Our ref: Trinity Grammar School Redevelopment-Mod-1 (SSD-10371-Mod-1)

**Subject:** Request for Additional Information

I refer to the Trinity Grammar School Redevelopment-Mod-1 (SSD-10371-Mod-1). After careful consideration, the Department of Planning and Environment (Department) is requesting that you provide additional information.

Figure 1

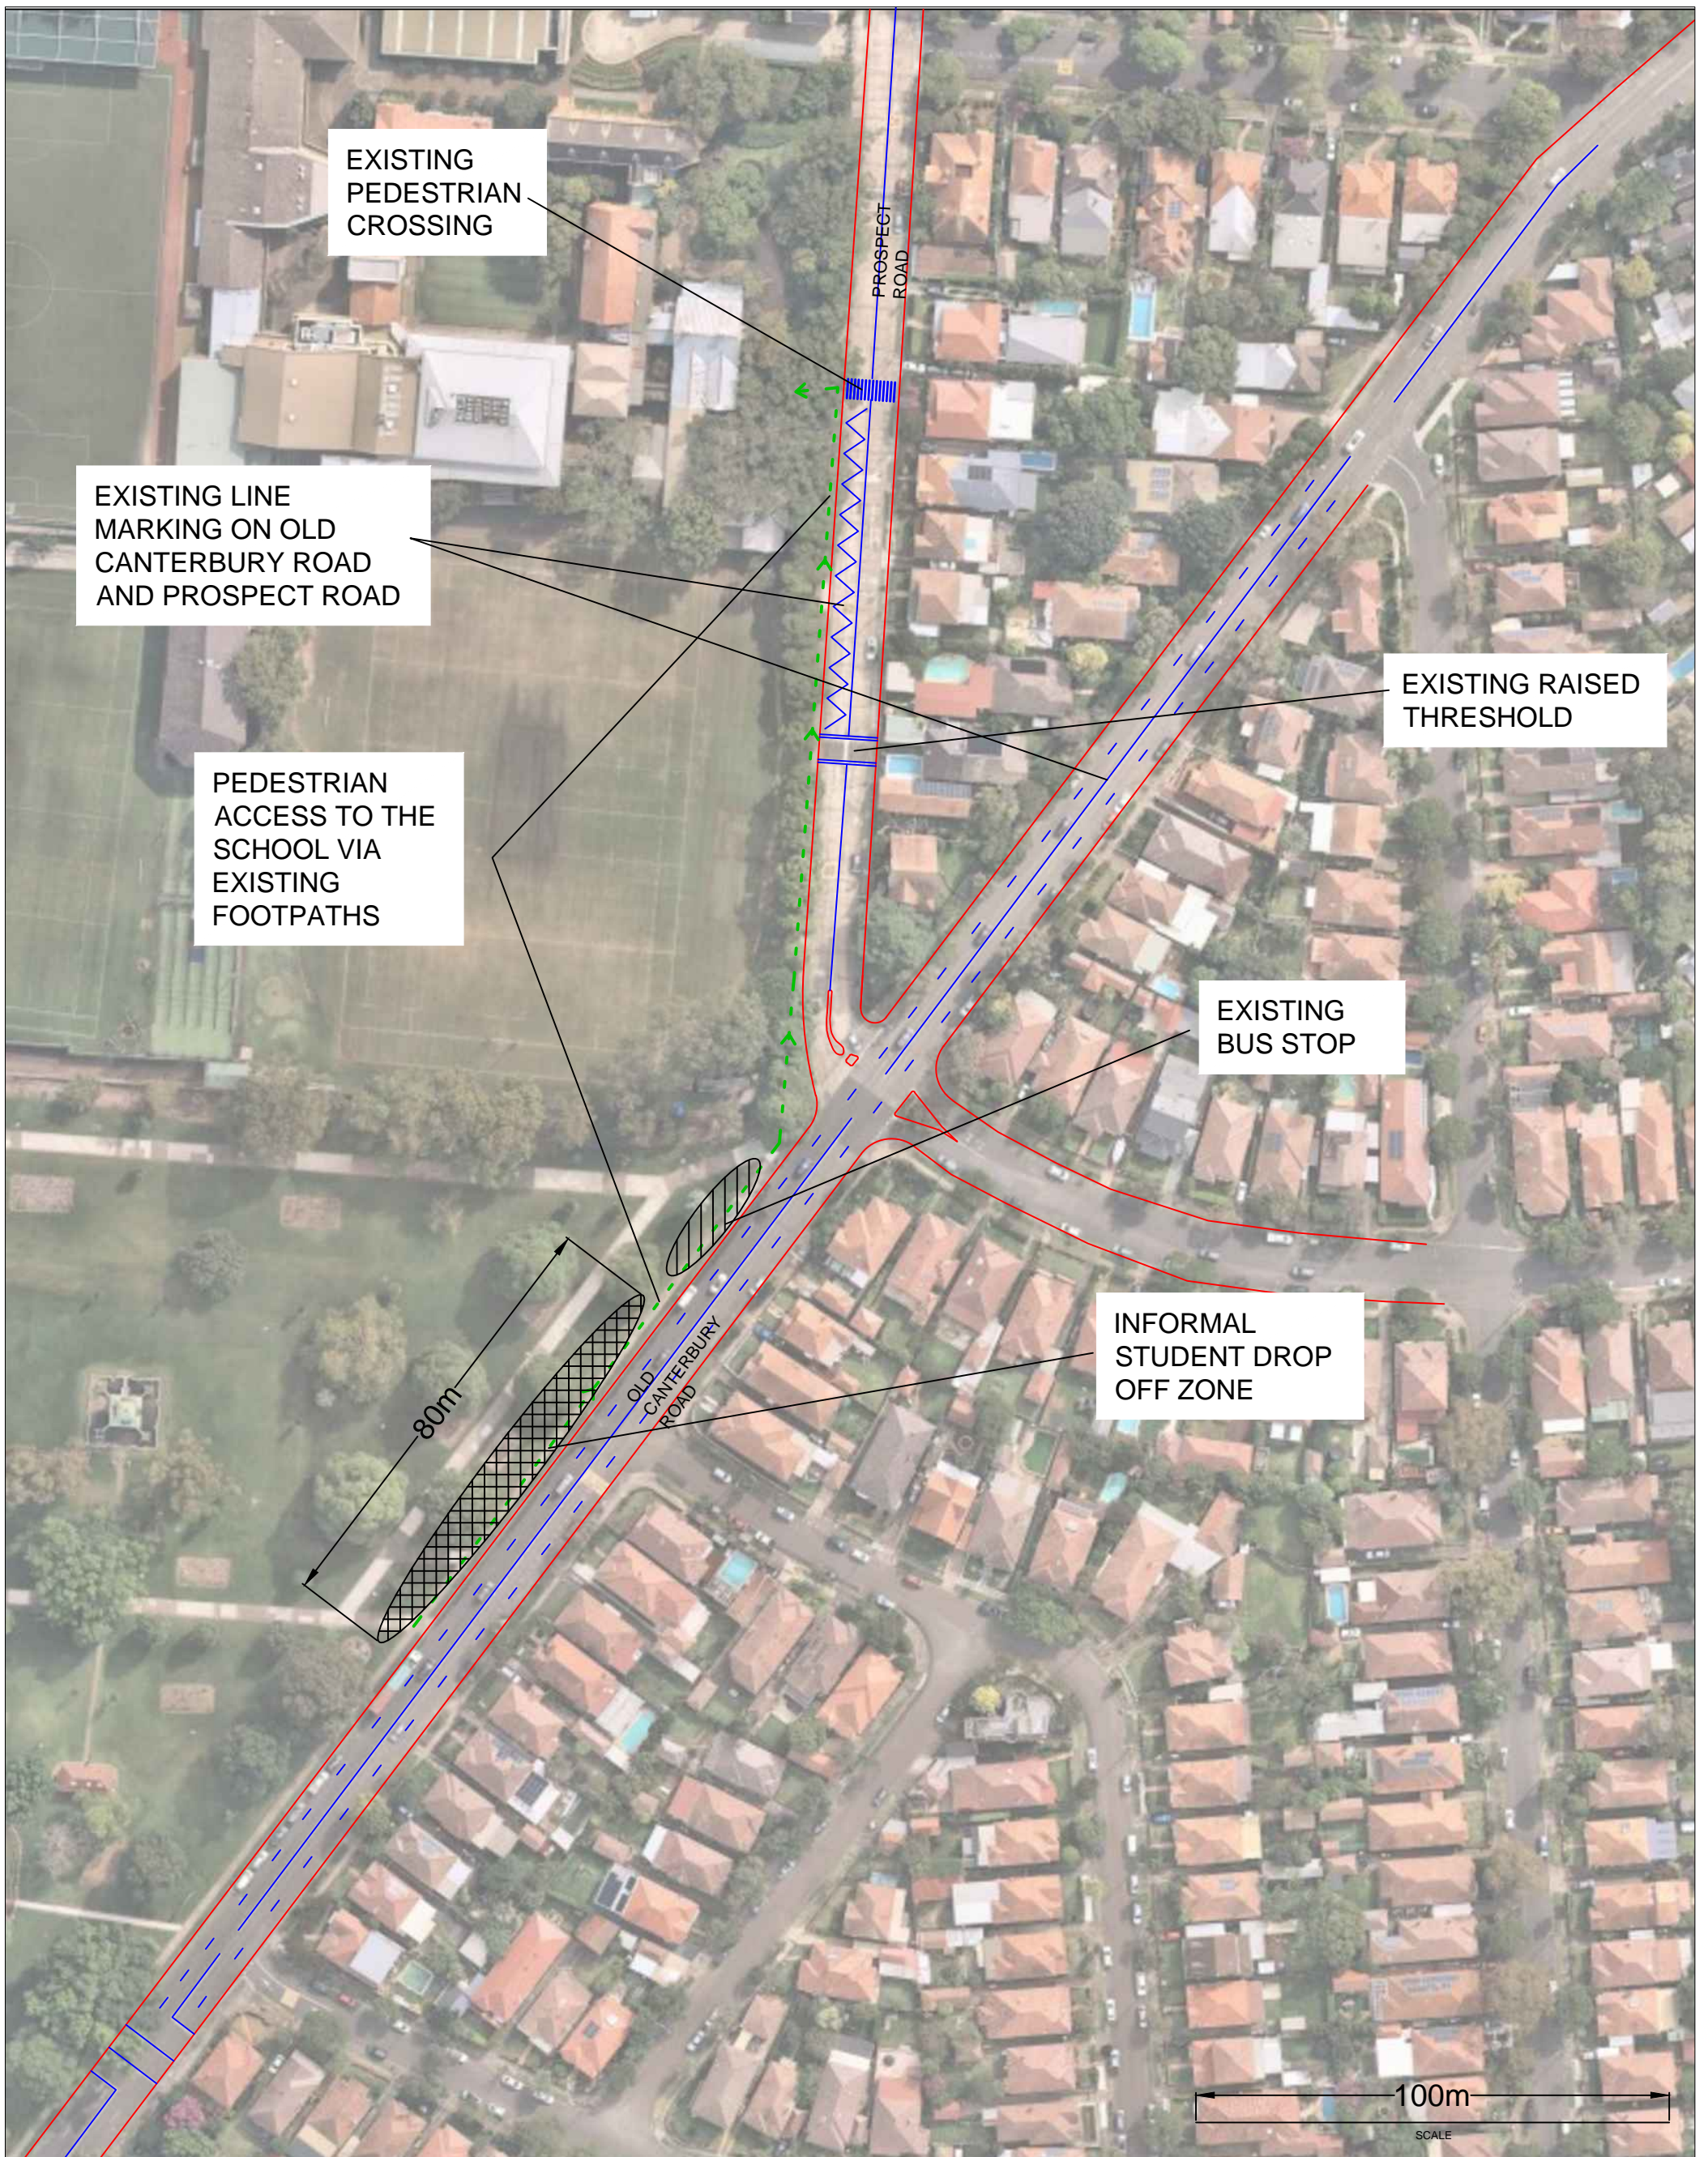
- Inner West Council (Council) has reviewed the response to submissions report (RtS) and requested that you address the following:
  - confirm whether the ‘informal’ drop-off zone on Old Canterbury Road would require appropriate signage to be placed to designate this area as a drop-off zone in the mornings and if required then identify what impacts that would have on the bus operational signage.

- include consideration that additional approval/endorsement may likely be needed from the local traffic committee (or TfNSW) to install required signage (if any).
